Please ask for: Ms Iqraa Malik
Email: iqraa.malik@terraquest.co.uk
Telephone: 01212341390
Our Ref: WA/92/20/HH
Your Ref:
Date: 2nd December 2020

Application for Planning Permission for Works or Extension to a Dwelling

Development: retrospective application for the construction of a singles storey rear extension
Location: 1 Fontwell Close Walberton BN18 0SW

Site Block Plan
1 : 500

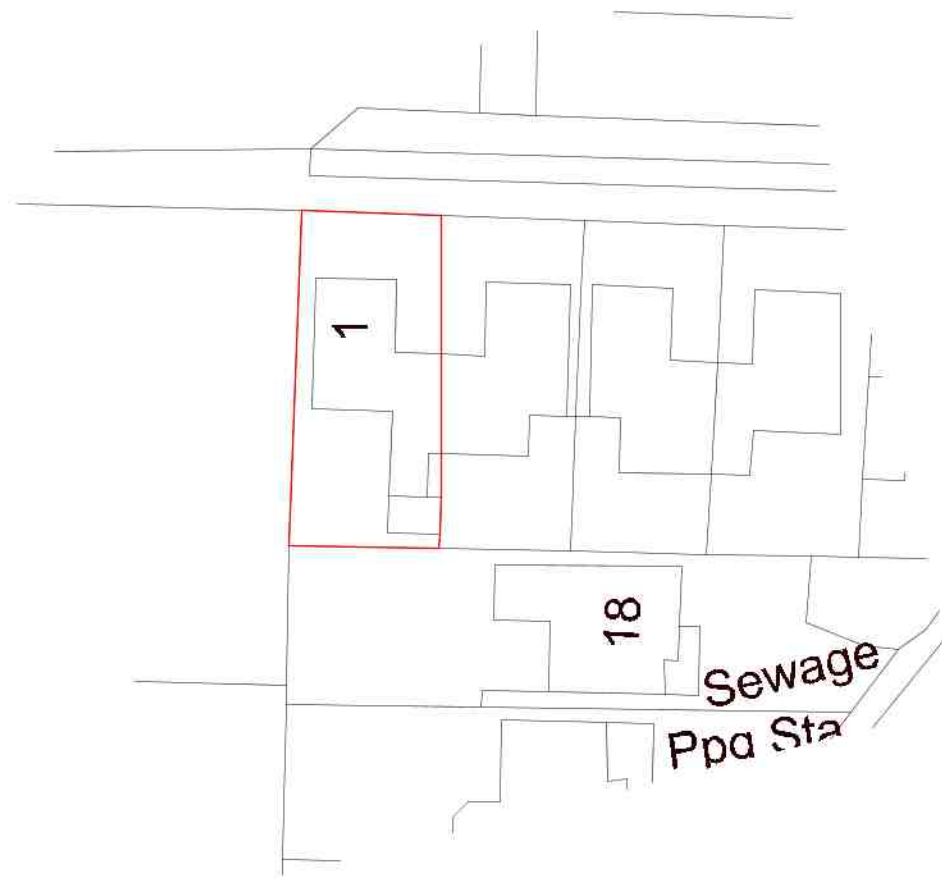
Block Plan

You are required to have dimensions from the proposed extension(s) to all site boundaries. Please amend,
